16 October 2017

Reference: WestConnex M4-M5 Link – SSI 7485

Thank you for the opportunity to review and comment on the Environmental Impact Statement for the proposed Stage 3 WestConnex M4-M5 Link Project. The following are our comments.

Figure 15-5 Indicative operational discharge points

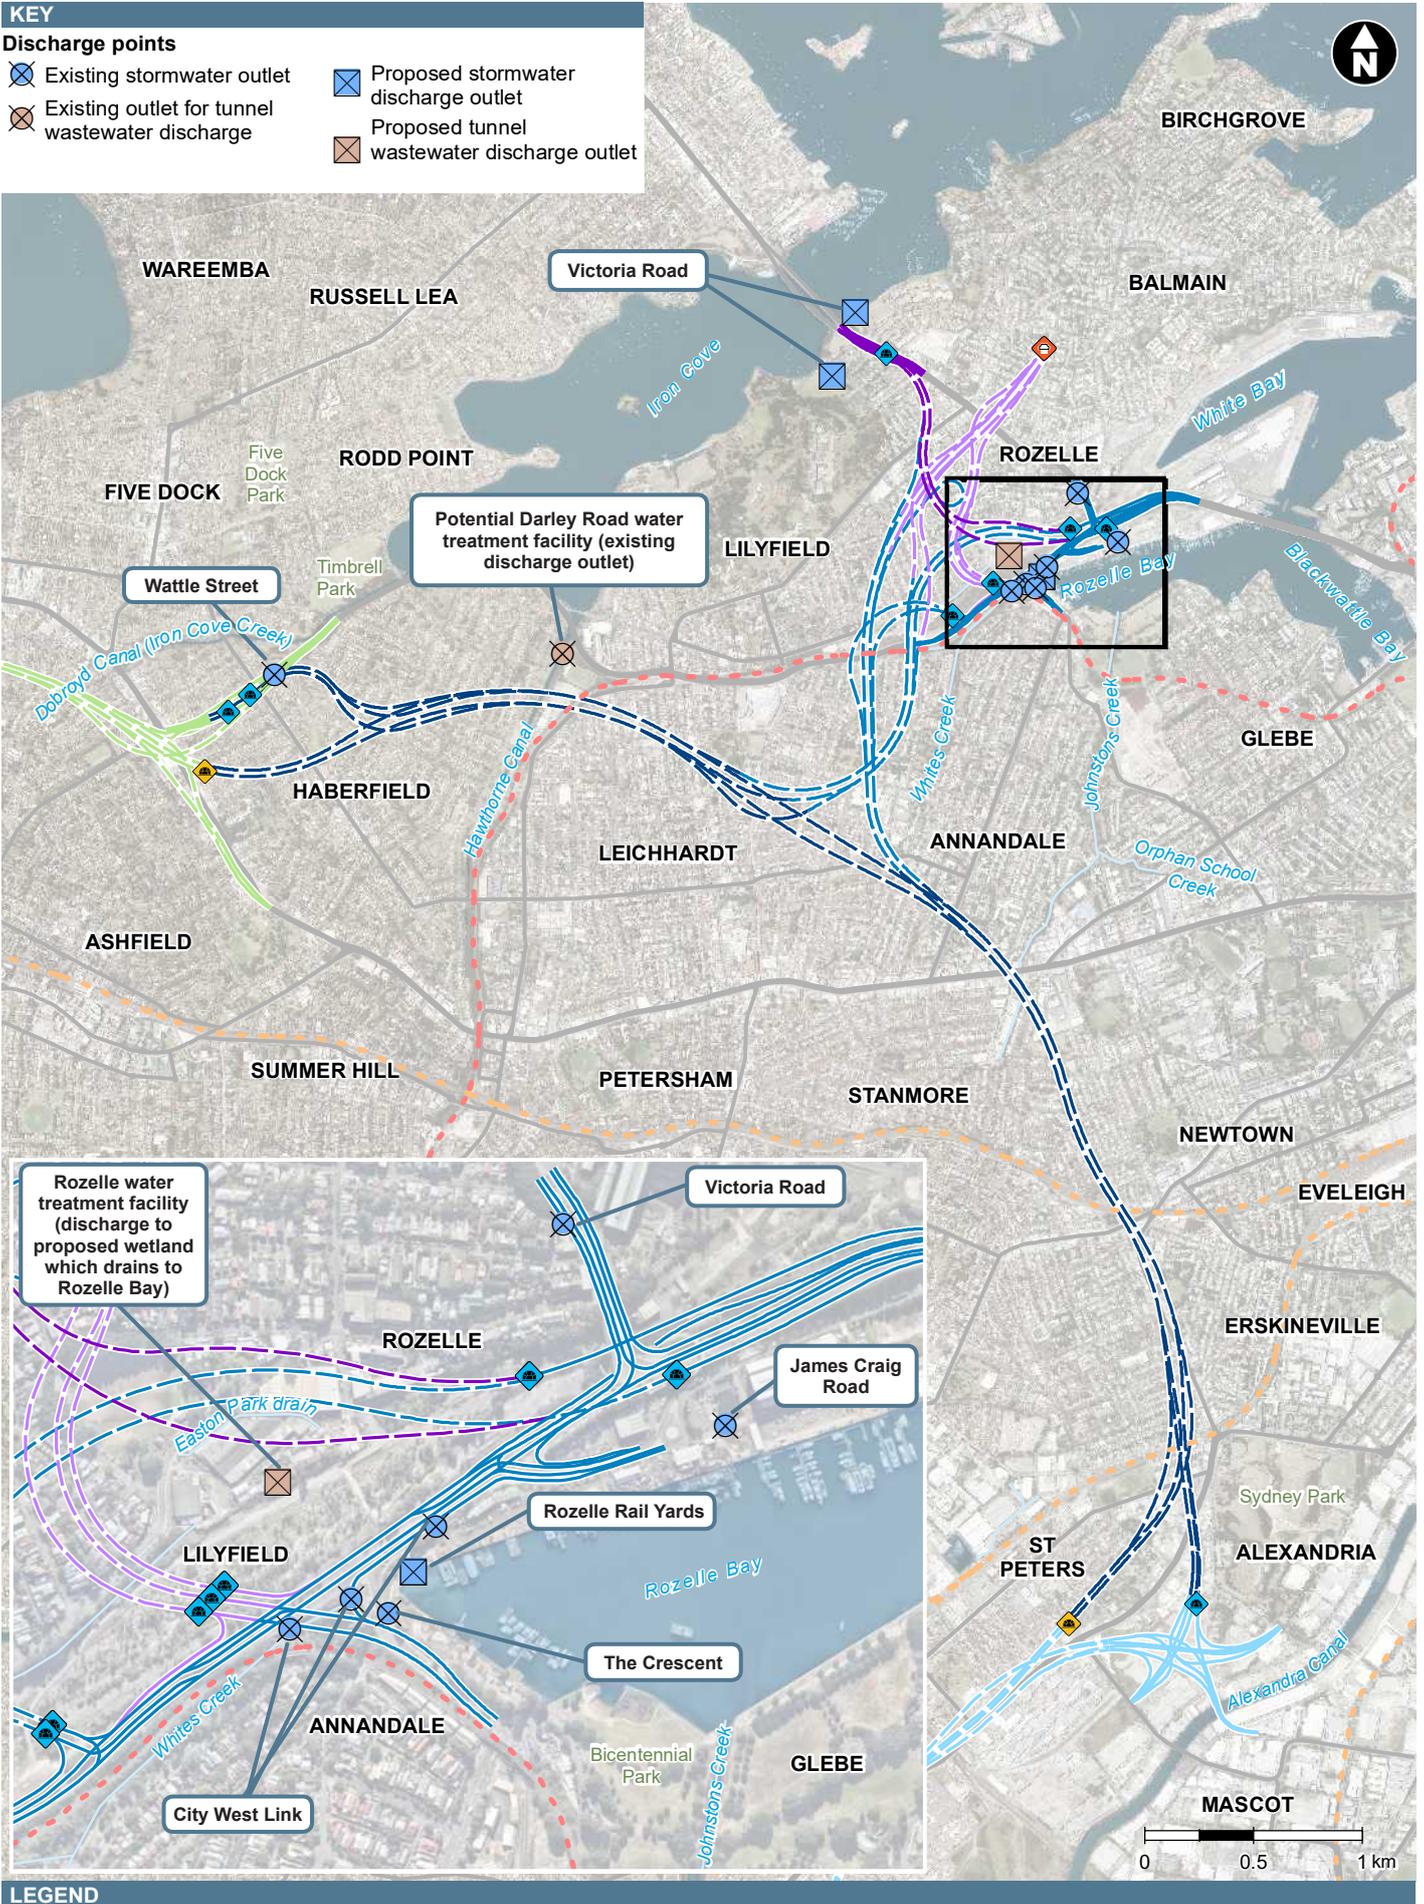
However, the EIS advises that the stormwater mean annual pollutant load reduction targets would not be achieved for the project or for the individual catchments, based on the treatment measures that could practically or readily be implemented. Table 15-12 ‘MUSIC modelling results for operational water quality’ shows that the project fails to meet 20 out of 25 pollutant reduction targets. Sydney Water is concerned that even at this early stage of project design development there appears to be a lack of application by the project to meet suitable targets.

- In view of the substantial annual volumes of groundwater delivered to the two concentrated outlets (Darley Road – Hawthorne Canal and Rozelle – proposed wetland), there is a potential for unsuitable quality groundwater to overwhelm benefits associated with current and future catchment wide stormwater management / treatment efforts by Sydney Water and Councils for these locations.

Sydney Water requests that the establishment of appropriate tunnel water discharge treatment targets be reviewed and determined by a suitable independent expert and that the project designers apply a high degree of verifiable effort to meet the targets.
